Response to Planning Application

Application ref: P/19/22/PL

Description: Erection of a Jump Tower with Climbing Wall and a Container Bar. This application may affect the setting of listed buildings and is in CIL Zone 4 (Zero Rated) as other development.

Location: Church Farm Holiday Village Church Lane Pagham PO21 4NR

1 Elevation A
Scale 1:50

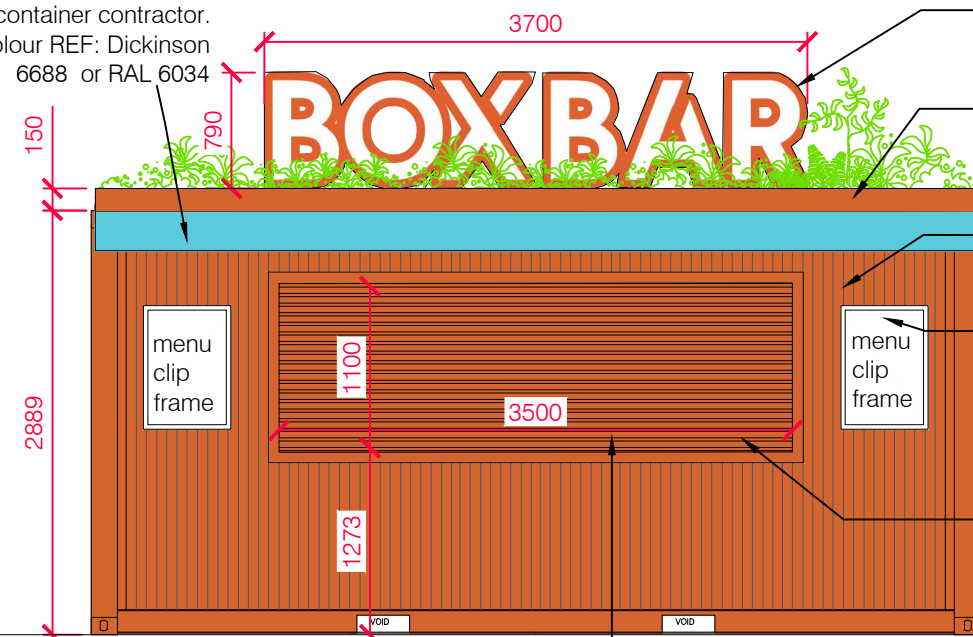
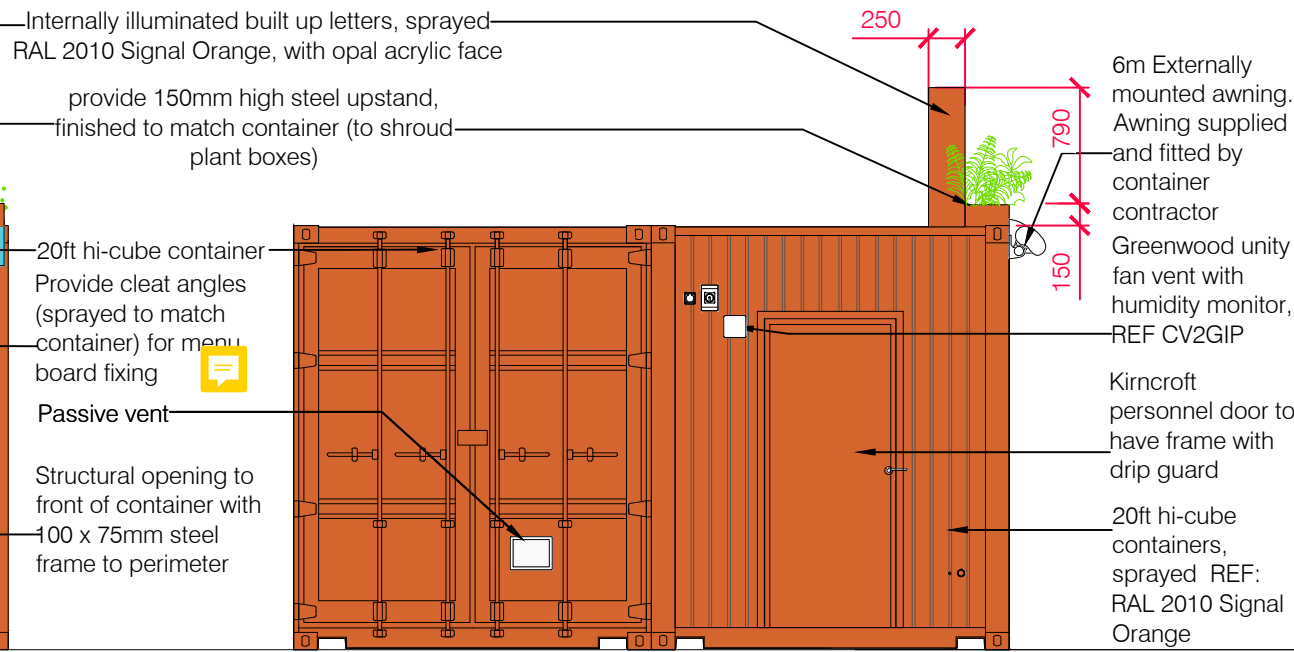
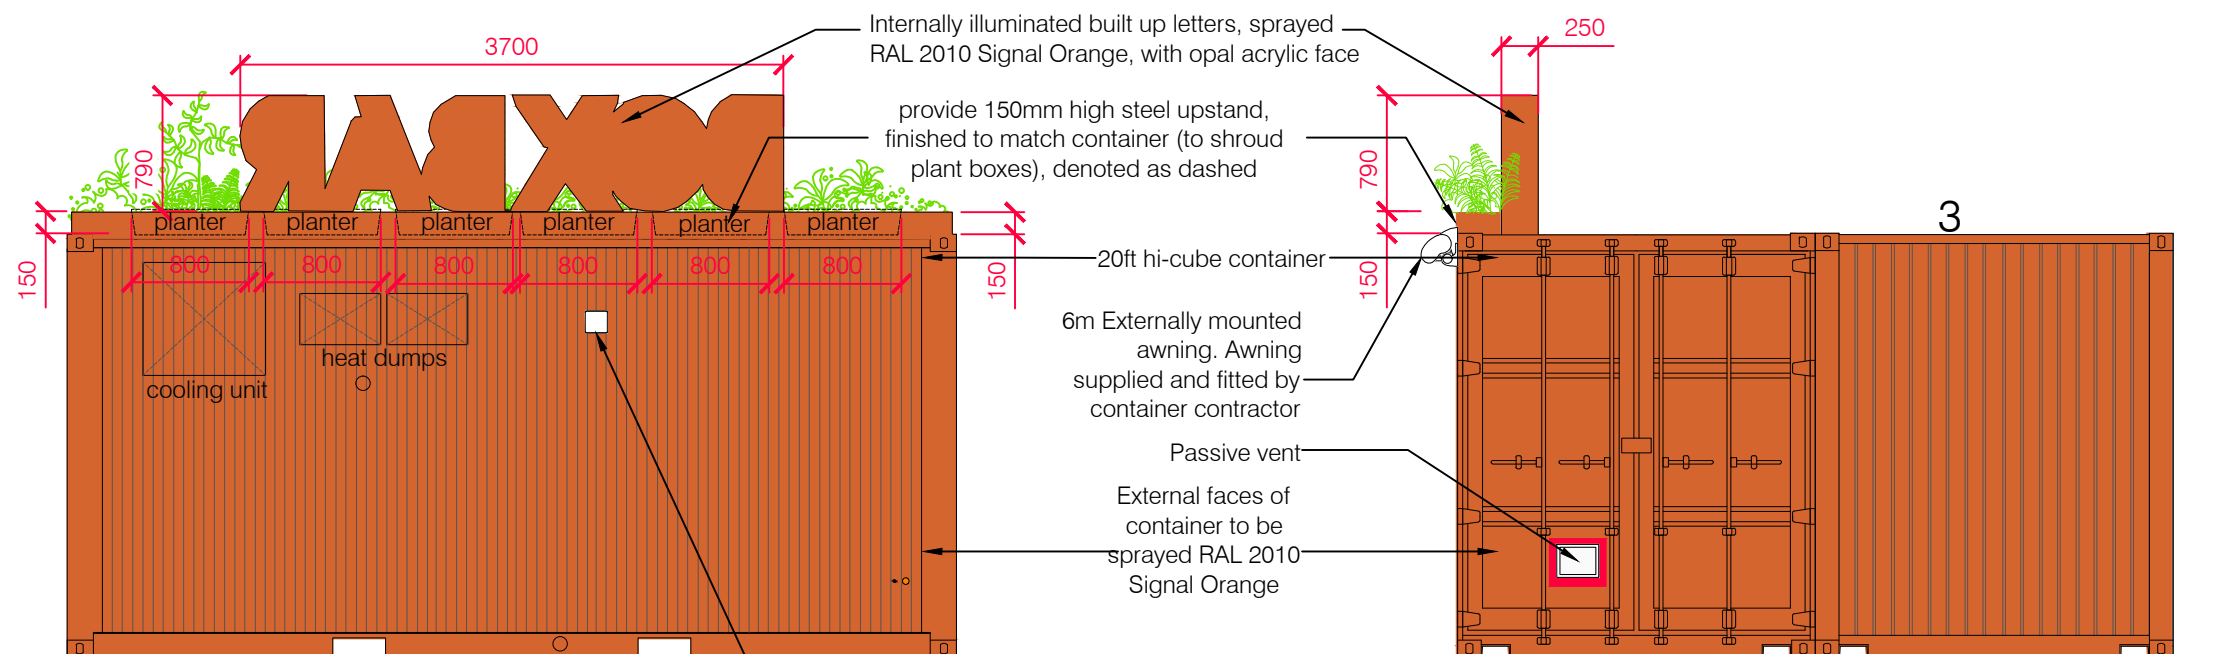
The container bar detail supplied in dwg 'Proposed floor plans and elevations 201A' has indicated a green roof to the structure, which we would be keen to see implemented for greening and biodiversity improvement purposes.

Indicated green roof to the structure to be implemented for greening and biodiversity improvement purposes. No additional landscape mitigation required for the proposals.
